Project # 7036 81st Ave SE, Mercer Island 98040

Correction Notice #1

Date: 12/10/20

Review Type: Fire, Land Use, Building, Civil, and Trees

**A202**

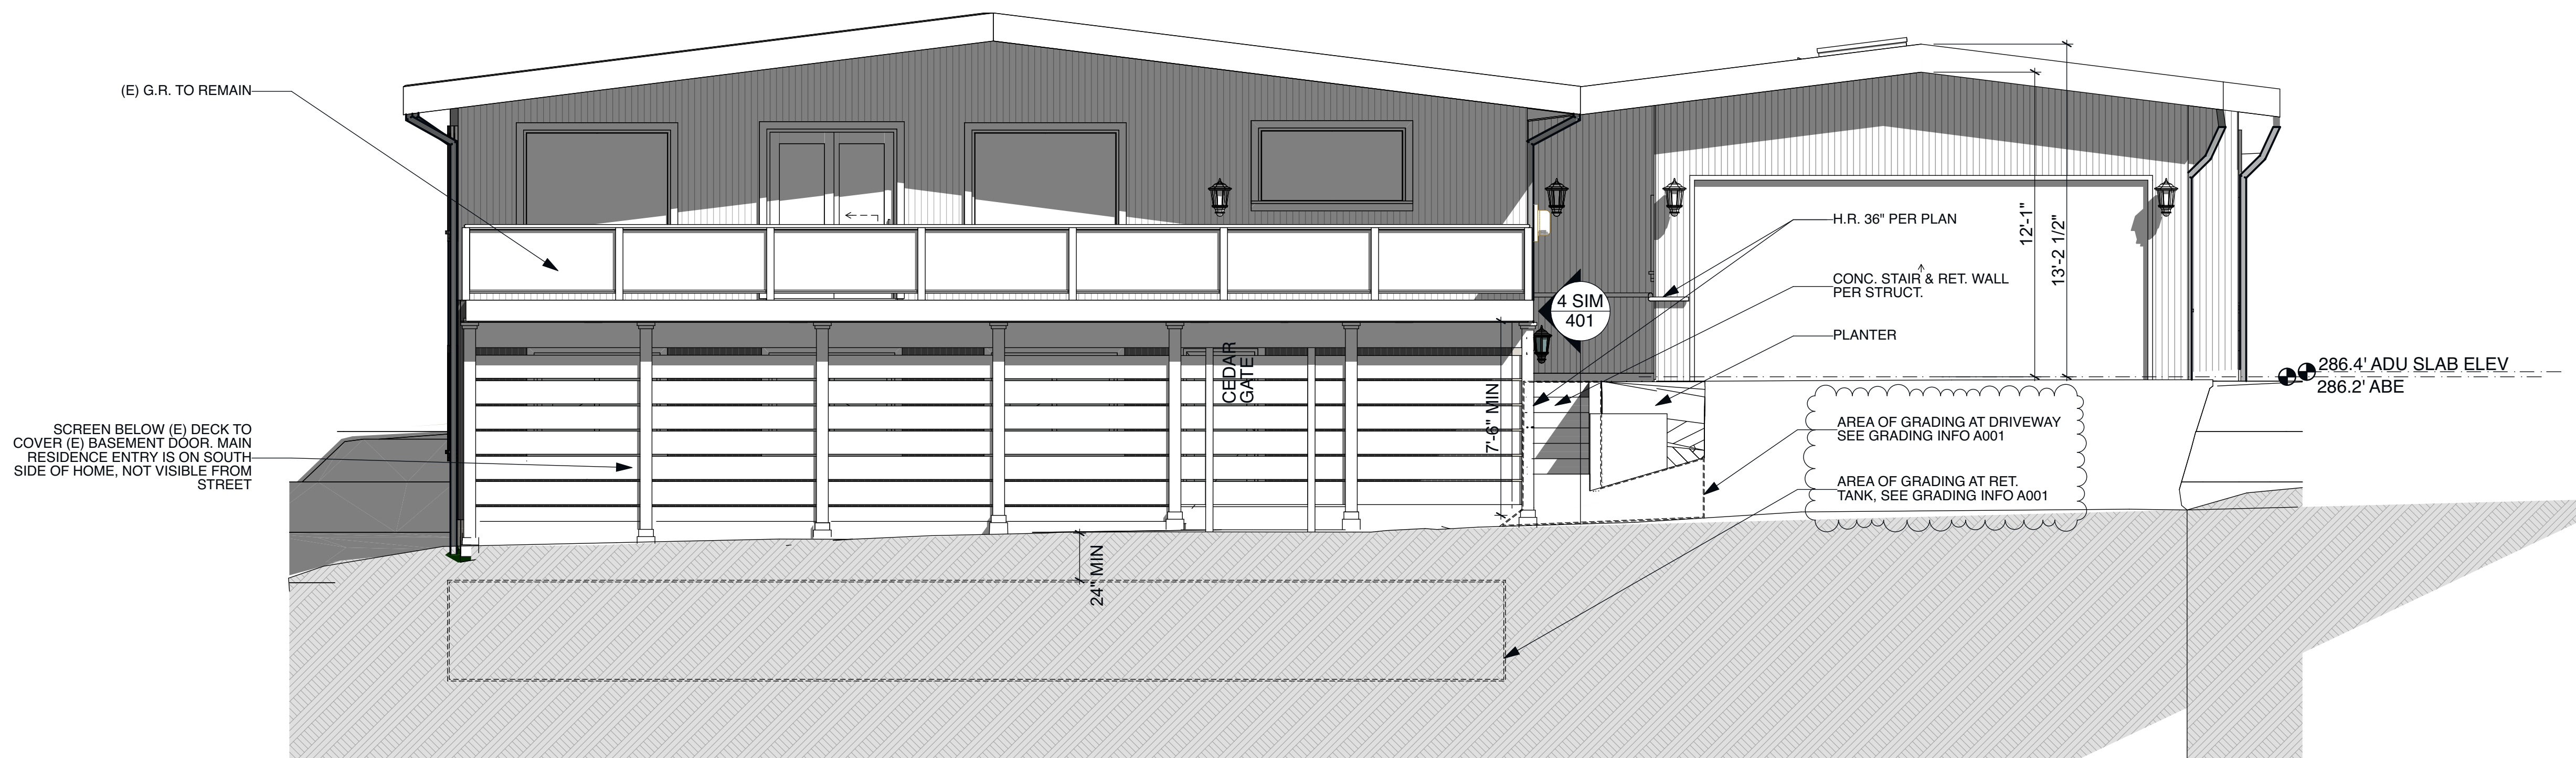
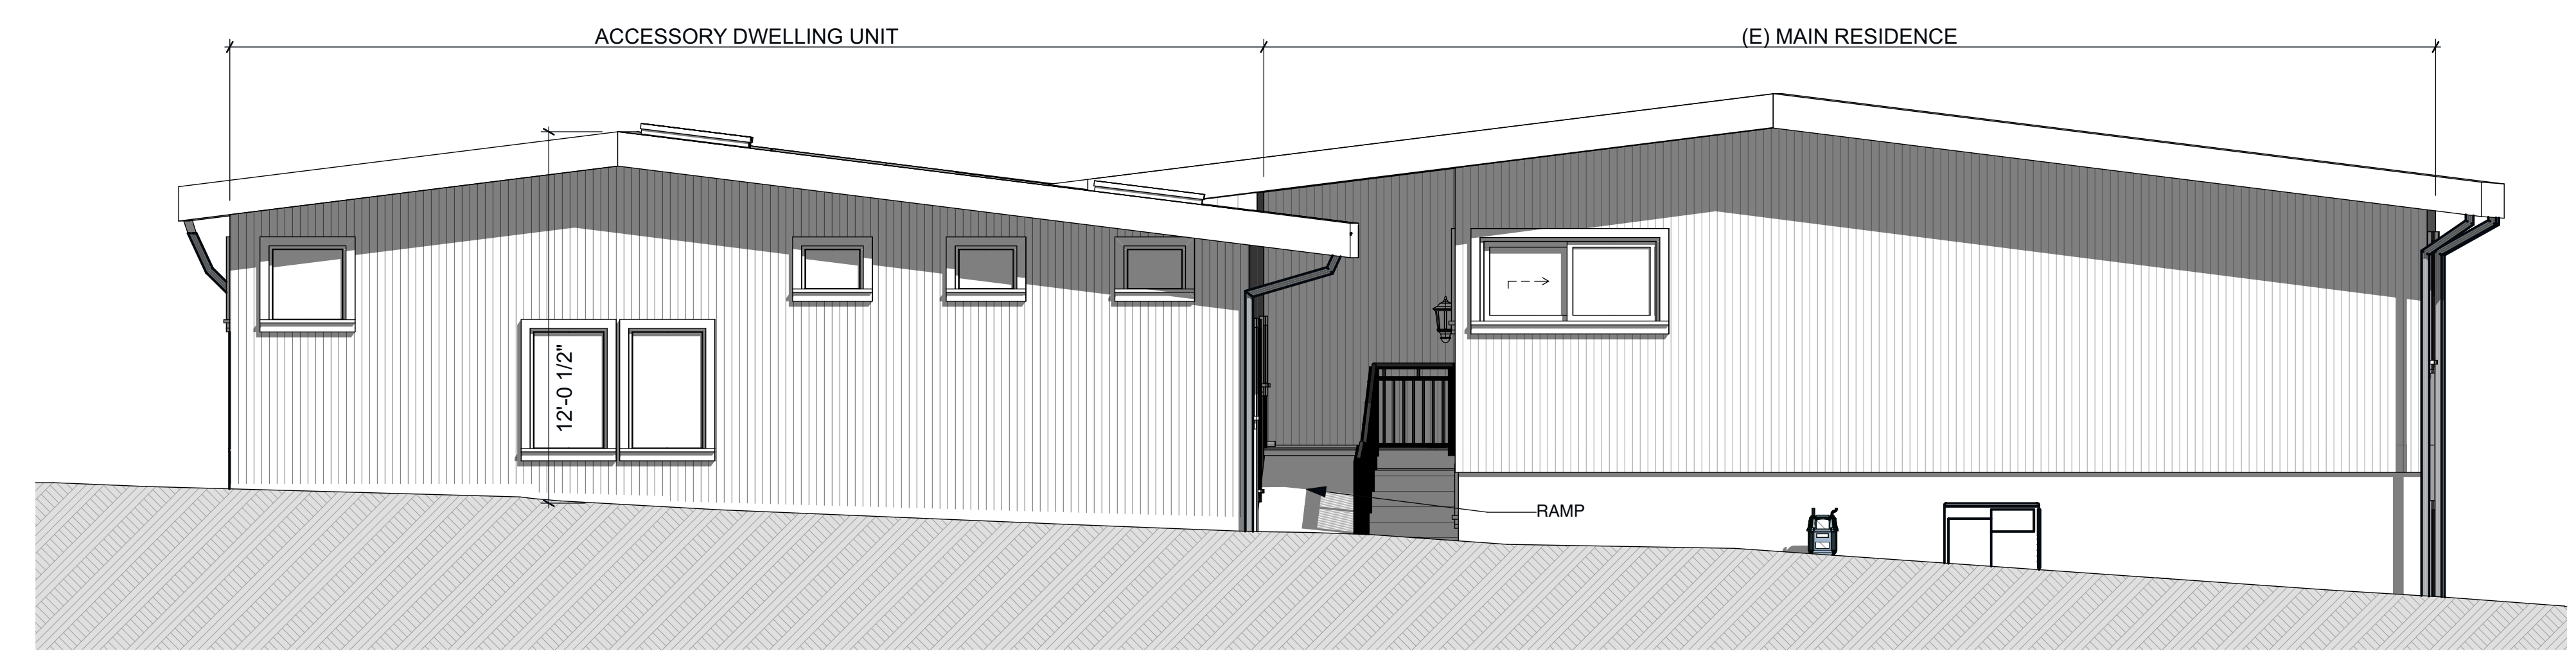
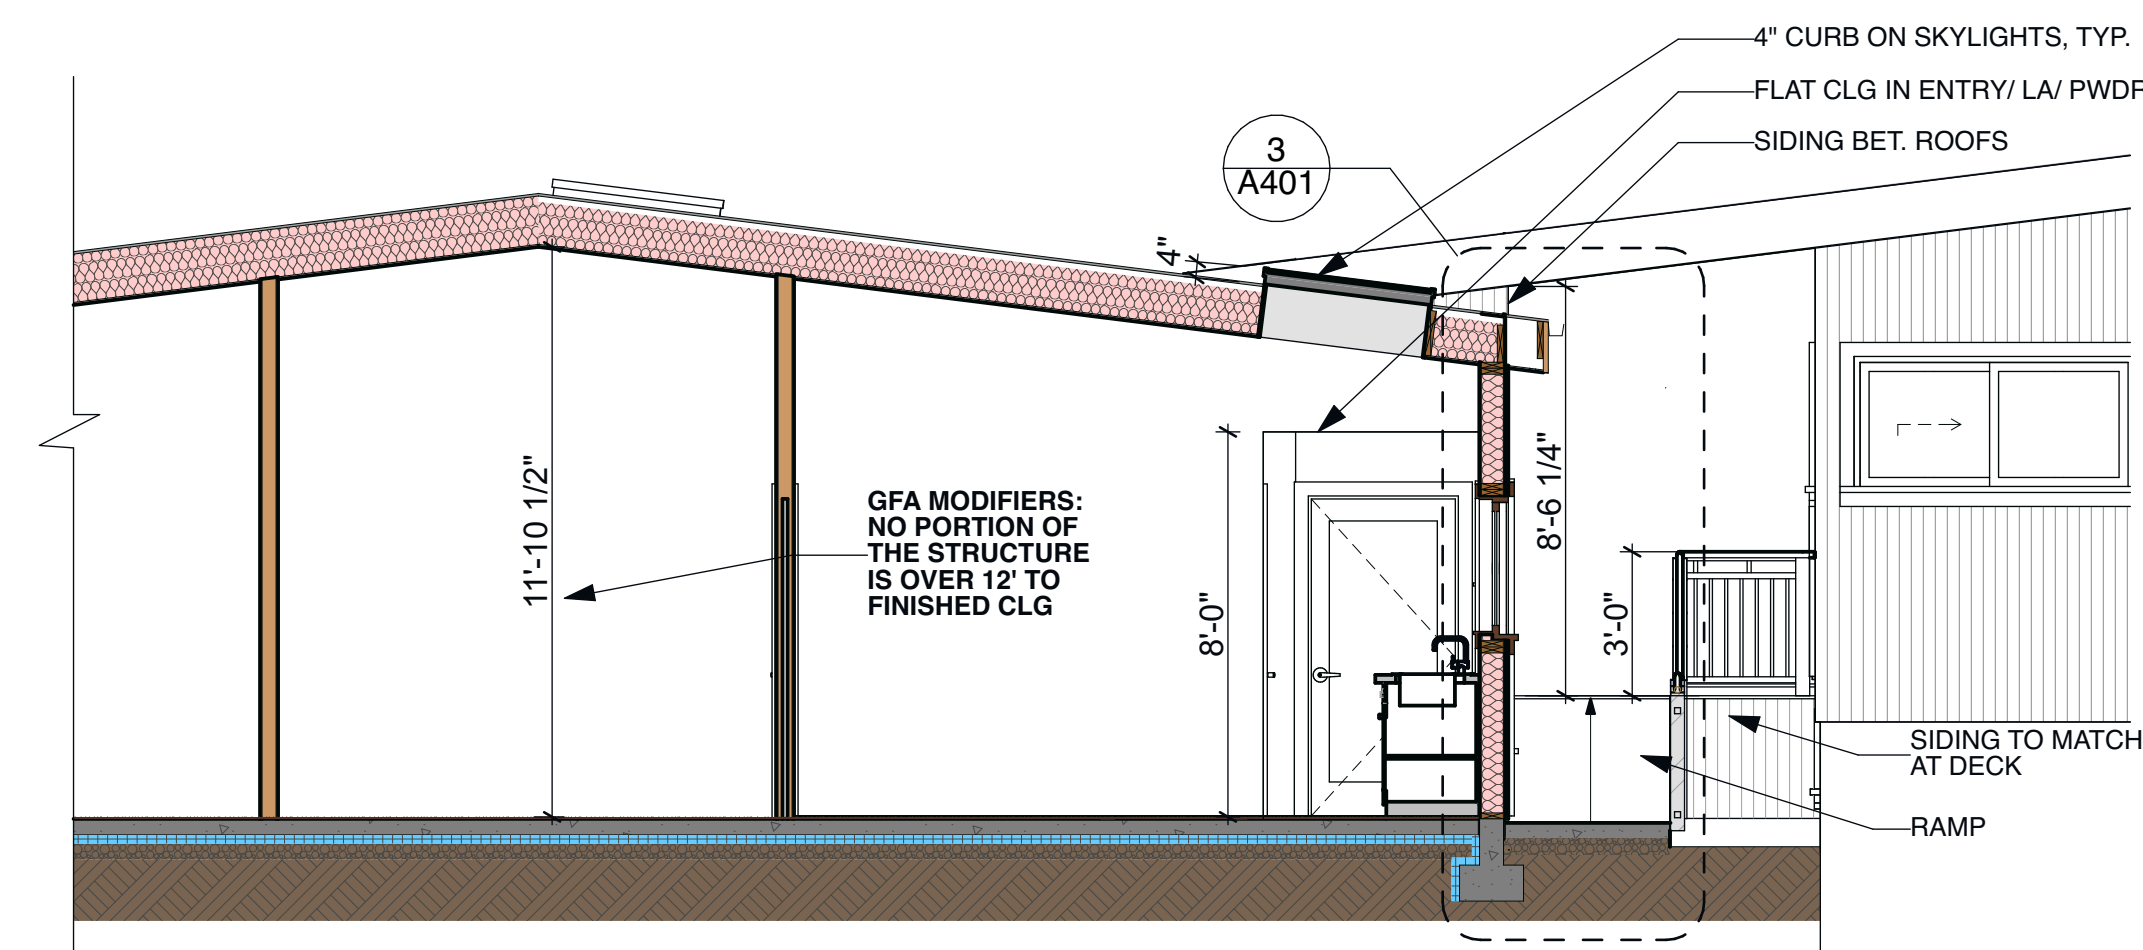
Indicate existing grade and finished grade, and the amount of grading outside the building footprint

Please see A202 for the required information
